**APPLICATION BY SEGRO PROPERTIES LIMITED FOR A
DEVELOPMENT CONSENT ORDER IN RESPECT OF EAST MIDLANDS
GATEWAY PHASE 2**

DEADLINE 4 SUBMISSION

PROLOGIS UK LIMITED AND PROLOGIS UK 121 LIMITED

Drawing Title
**ILLUSTRATIVE
LANDSCAPE
MASTERPLAN**

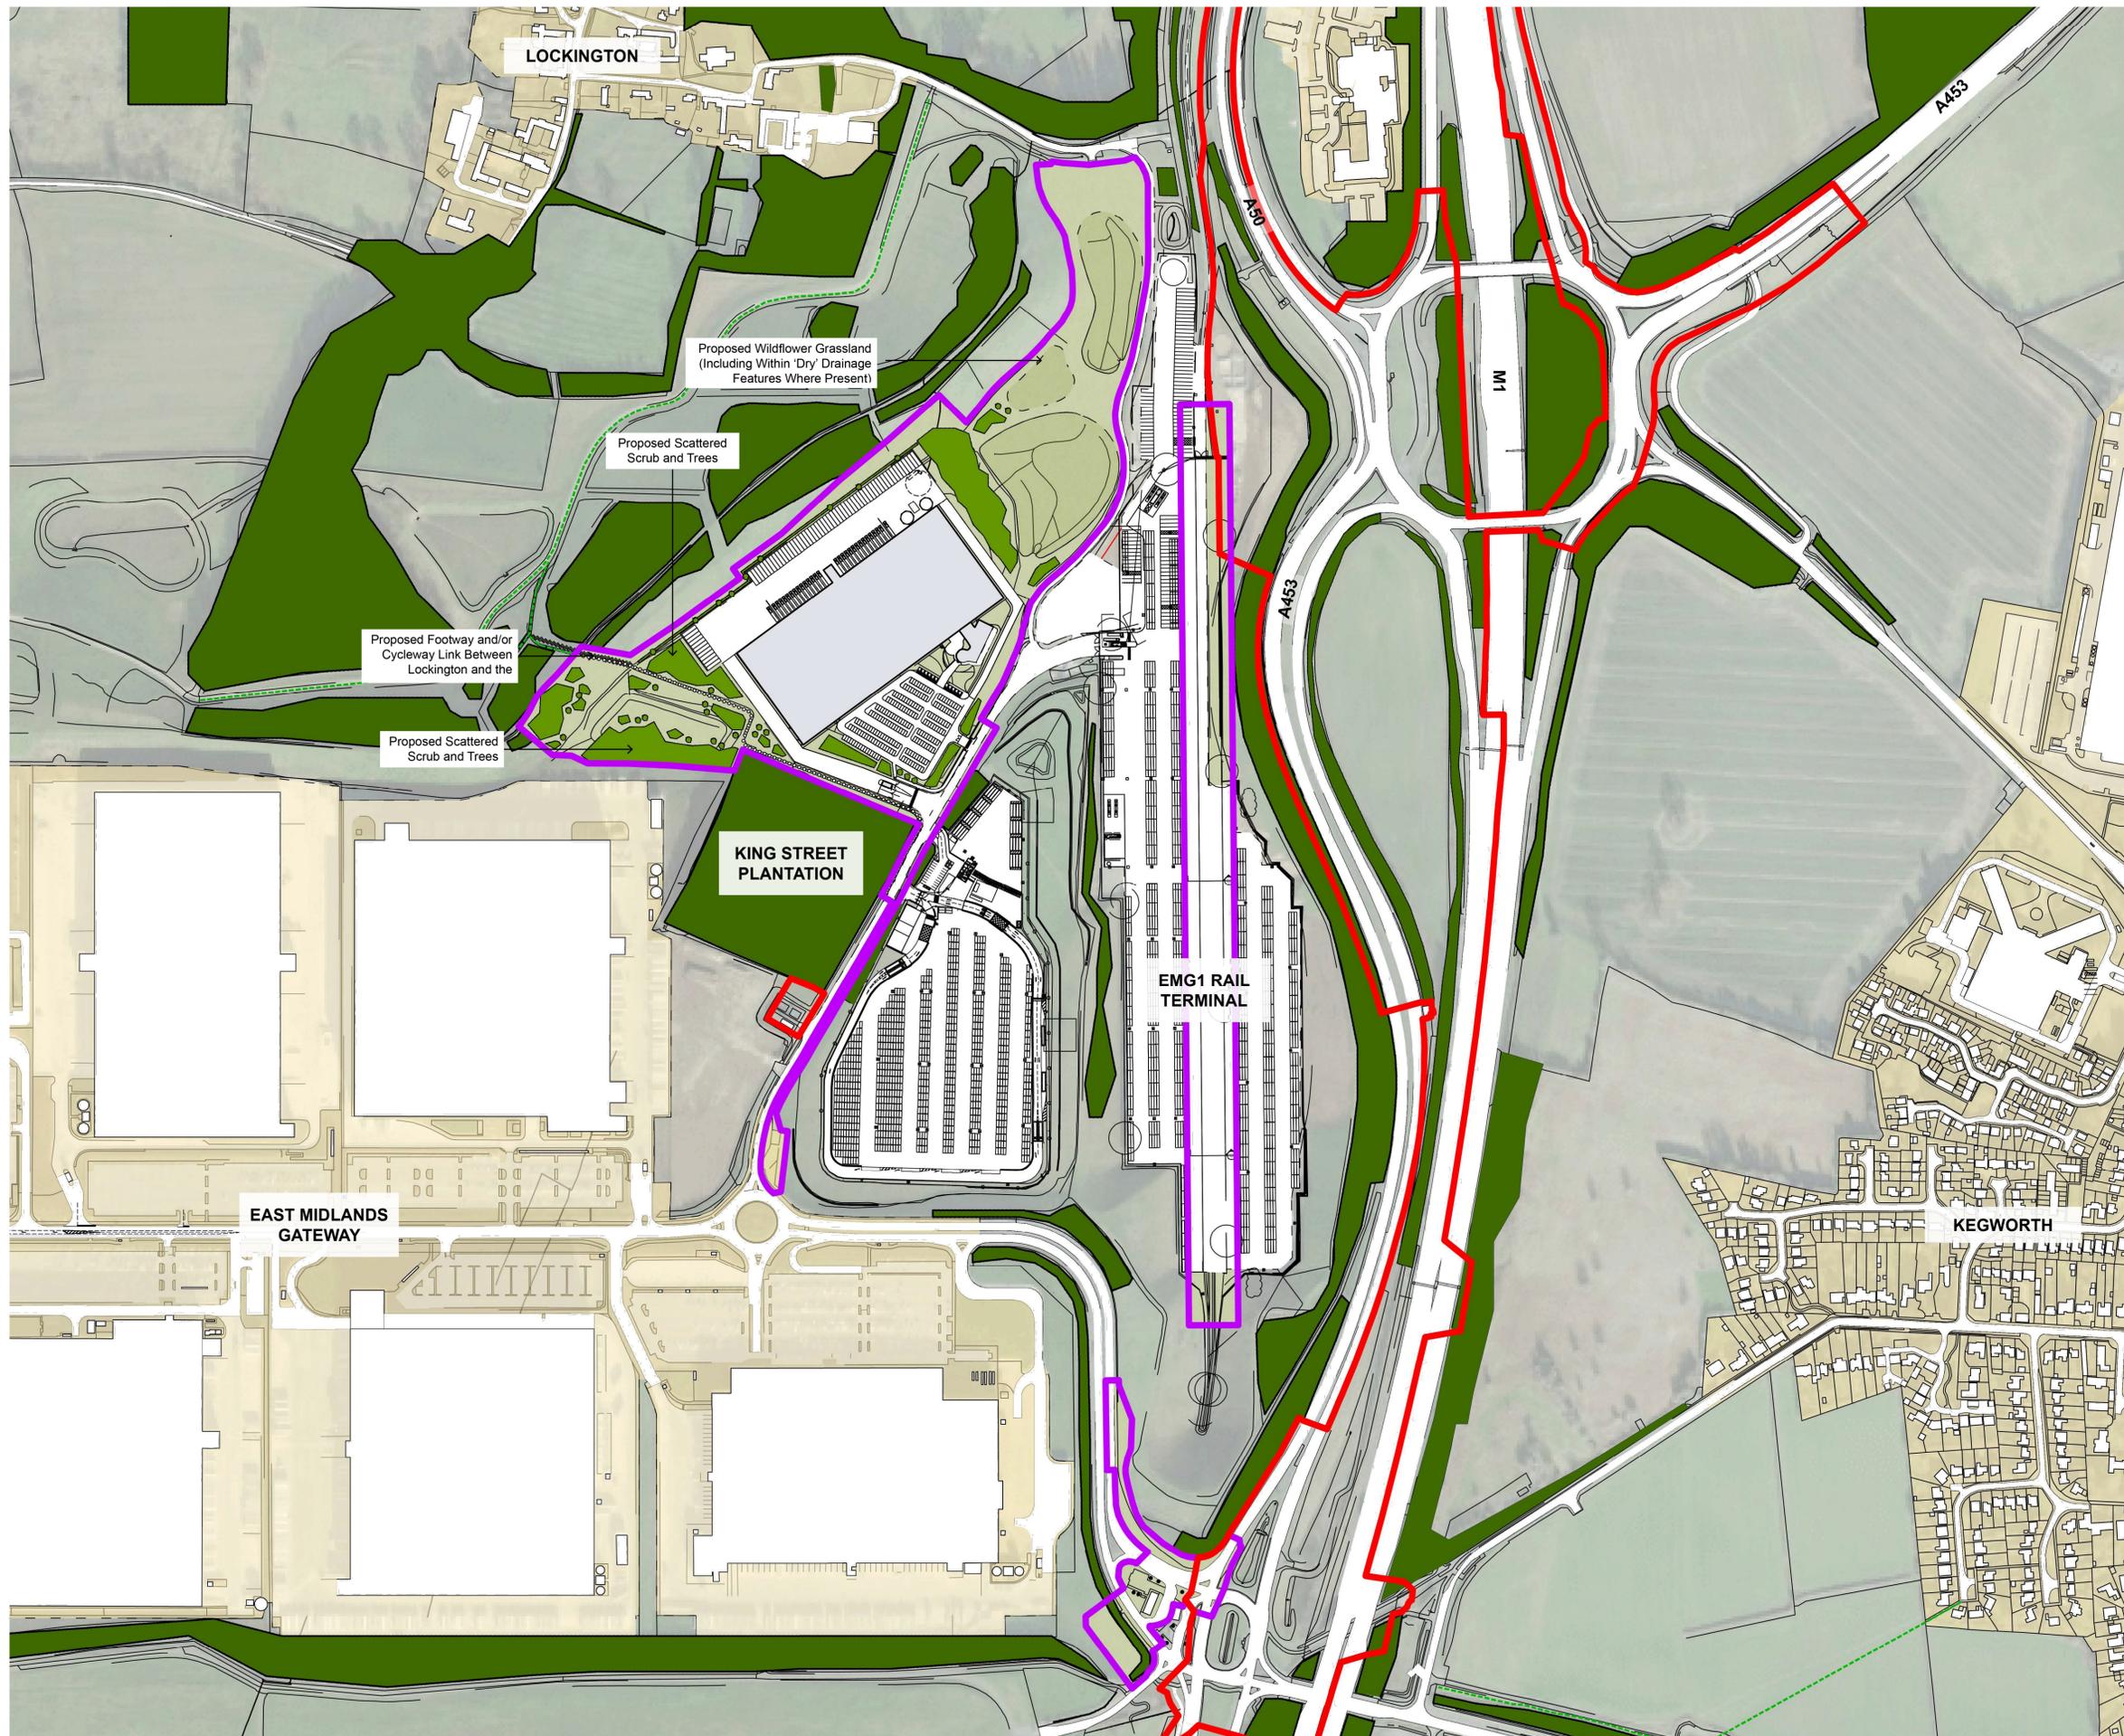
- 3.11 The Vision Document (Appendix 4 to the Section 35 Application) presented this masterplan⁴ with genuinely campus-like components: a standalone office building distinct from the warehouse provision (Unit 3b) served by car parking spaces, a two-storey hub (Unit 3c) with associated sports facilities, a chilled warehouse with two-storey offices and a separate transport office (Unit 3a); and a plot expressly named “Plot 1 – Campus Development” consisting of a warehouse and multiple offices. Taken together, those elements occupied roughly a third of the s35 Direction site and conveyed something materially more than a conventional logistics scheme and more akin to the number of corporate campuses found around the country, where a large company of strategic importance draws together disparate functions on a single landscaped site so as to benefit from the synergies of co-location.

- 3.26 In the meantime, it is instructive to compare the masterplan provided to the Secretary of State in the Section 35 Application documentation (see paragraph 3.11 above) with the masterplan that now underpins SEGRO's viability material. The latter has stripped out the very features identified in the Direction.⁸ The standalone offices, the hub and the sports facilities have been removed and replaced with two standard warehouse units, leaving only a single unit carrying the (unexplained and apparently arbitrary) label "Plot 1 - Campus Development". However, this unit is described as comprising a warehouse, gatehouse and offices – the same three functions shared by every other unit illustrated on the masterplan, and indeed on masterplans and planning permissions for many other typical/standard logistics developments around the country. It is therefore unclear how this configuration of units differing in size but of the exact same functions can be regarded as the nationally significant corporate campus and free-standing headquarters described in SEGRO's s35 submission and the s35 Direction.
